**Subject: Canal Landing New Yard – Phase 1**  
**40 West Commercial Street**  
**Applicant: New Yard, LLC**  
**Condition Compliance Letter #1**

On behalf of New Yard, LLC, we are pleased to provide evidence of compliance with the City of Portland Planning Board's Conditions of Approval #4, 6 and 8 regarding the Final Site Plan Application for Canal Landing project in Portland. For ease of review, conditions of approval are repeated below (*in italics*) followed by our compliance.

DRAWN: CMW DATE: APR 2012  
 DESIGNED: RJW SCALE: 1" = 50'  
 CHECKED: SRB JOB NO. 3091  
 FILE NAME: 3091-SITE LAYOUT  
 SHEET: C-2.1

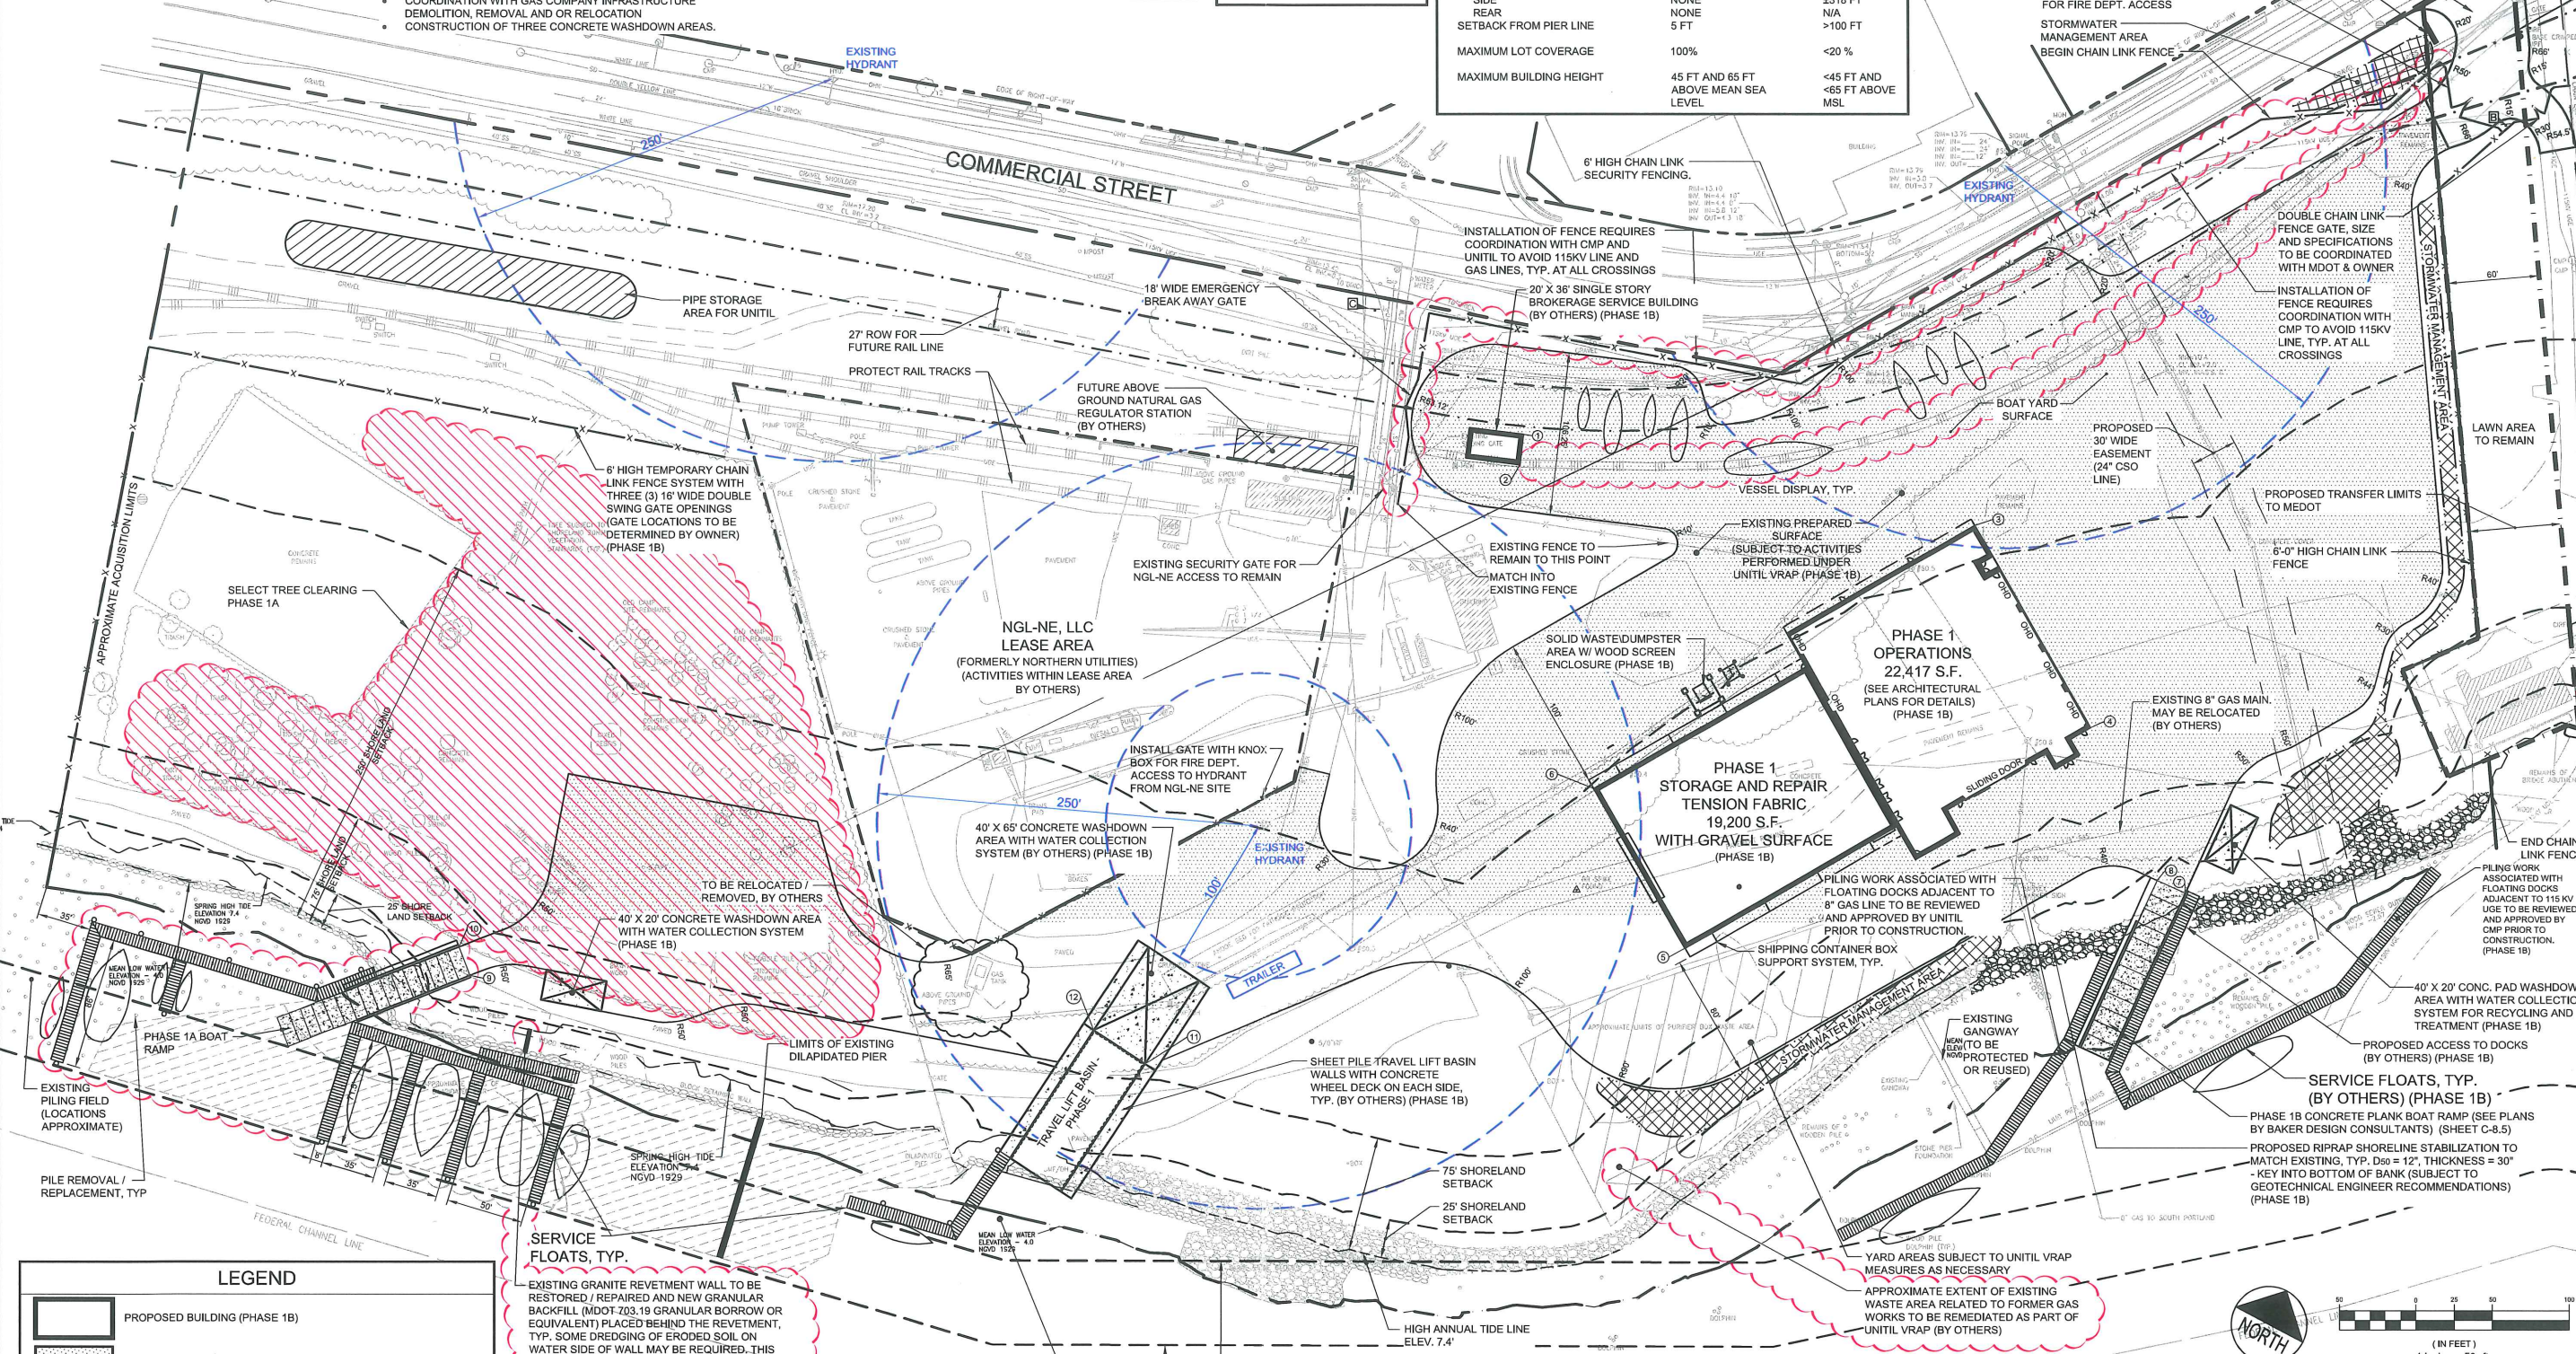
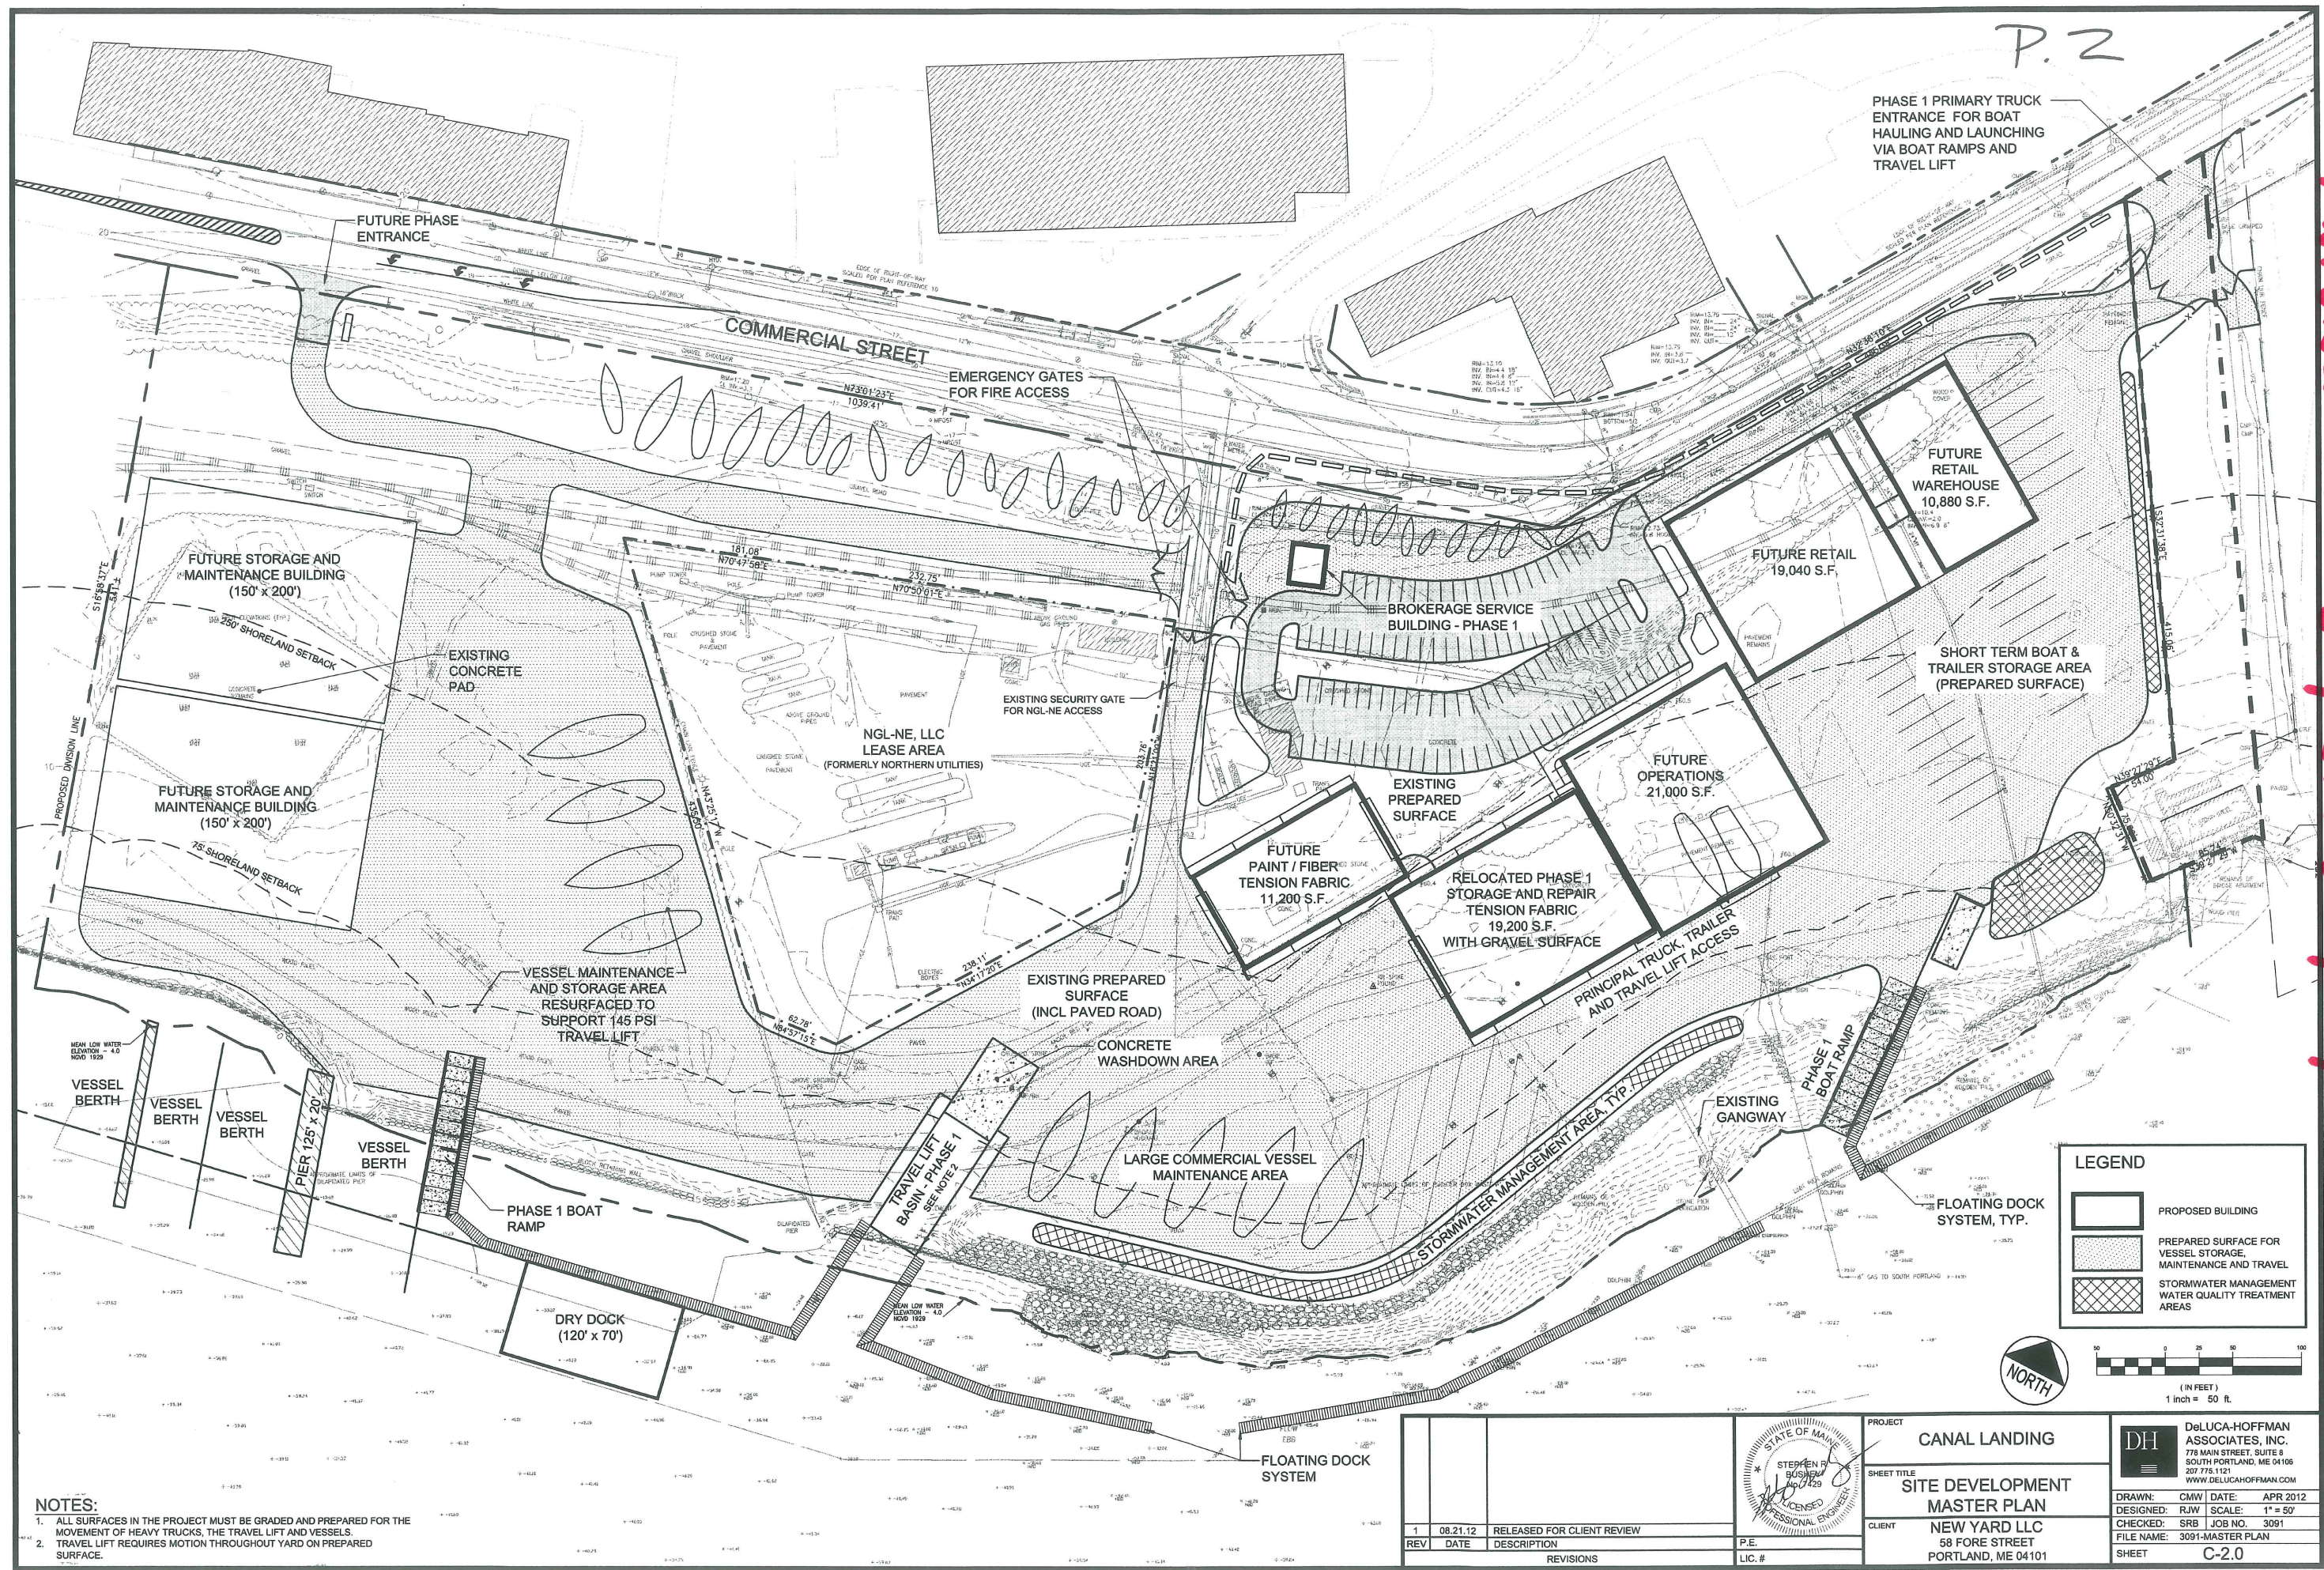
*Other Agency Reviews: That any modifications to City approved plans to meet outside agency requirements must be identified and submitted to the Planning Authority for final review prior to issuance of a building permit. Outside agency permits include, NRPA wetland alternation permits, Maine DEP VRAP approvals, and Portland Harbor Commission approvals.*

*Flood Plain Management: That prior to issuance of a building permit, the final site plan is revised to include a note requiring that structures on lots in the development be constructed in accordance with Portland City Code, section 14-450.8, Flood Plain Management.*

To satisfy the Portland Harbor Commission (approved January 10, 2013), the service float layout was revised. The attached Site Plan C-2.1 shows the revised float layout. Any plan changes associated with NRPA and VRAP approvals will be submitted to the City for review. The NRPA application is currently under review by the MeDEP and ACOE and it is anticipated that their finding and approvals will be forthcoming towards the end of February.

This note has been added to the Phase 1 Site Layout Plan (C-2.1).
